From: Adderbury Parish Council Clerk
Sent: 19 January 2018 19:25
To: Caroline Ford
Cc: Planning; Bob Duxbury; Diane Bratt; Thomas Darlington
Subject: 17/02394/OUT - OS Parcel 9100 Adjoining And East Of Last House Adjoining And North Of Berry Hill Road

17/02394/OUT - Hollins Strategic Land LLP - OS Parcel 9100 Adjoining And East Of Last House Adjoining And North Of Berry Hill Road - Outline planning permission for up to 60 dwellings with associated landscaping, open space and vehicular access off Berry Hill Road.

Adderbury Parish Council objects to the above planning application, on the following grounds:

Appendix 5:
Tree Constraints Plan
 Berry Hill Rd, Adderbury
 Ref: AWA1949

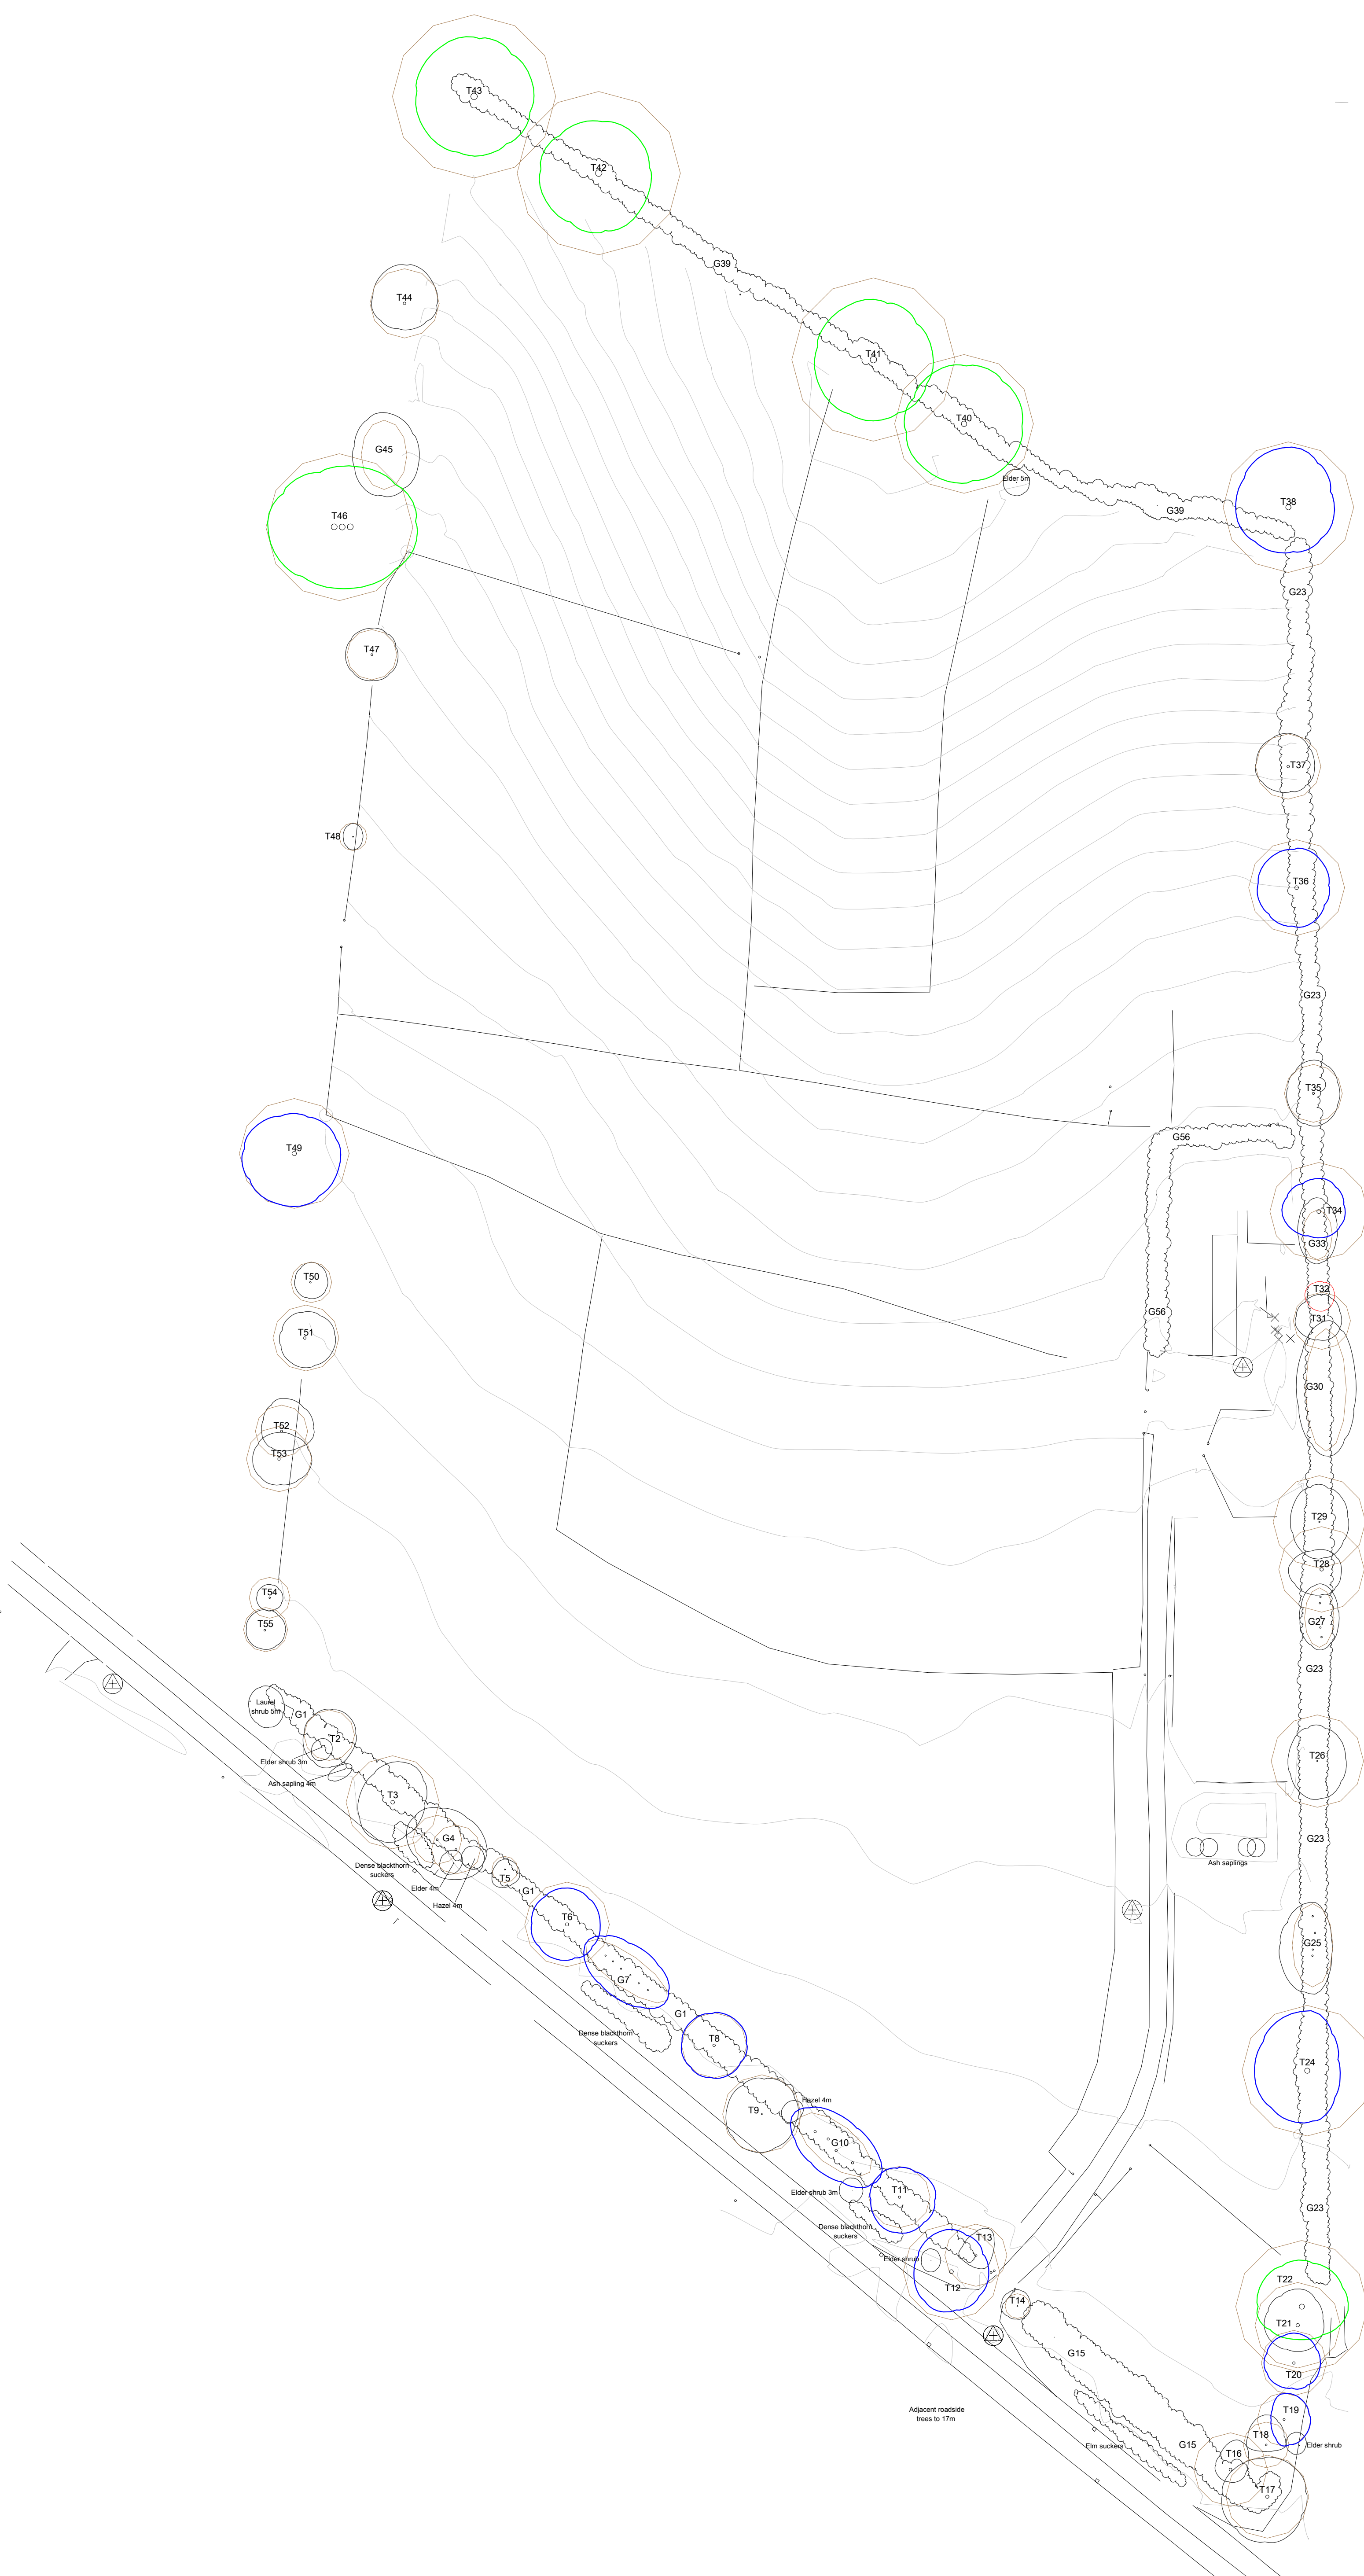
With regards the trees on the above site, it is proposed that the majority of trees on site are retained. The only trees to be removed for the development are one maple (T2), one Horse Chestnut (T3) and a section of hawthorn hedge (G1). The trees are of low value and have been categorized as C trees in accordance with BS5837:2012. Such trees should not normally pose a constraint for development. The section of hawthorn hedge is currently unmanaged and its removal will not have a significant impact on views into the site. The applicant will need to produce an Arboricultural method statement with details of the proposed protective fencing and a finalised tree protection plan. Based on the illustrative masterplan there appears to be plenty of space for the planting of trees on site. We will need to see details of any proposed tree planting and the proposed tree planting pits. I have no objections to the proposal as long as the below conditions are attached to any consent given.
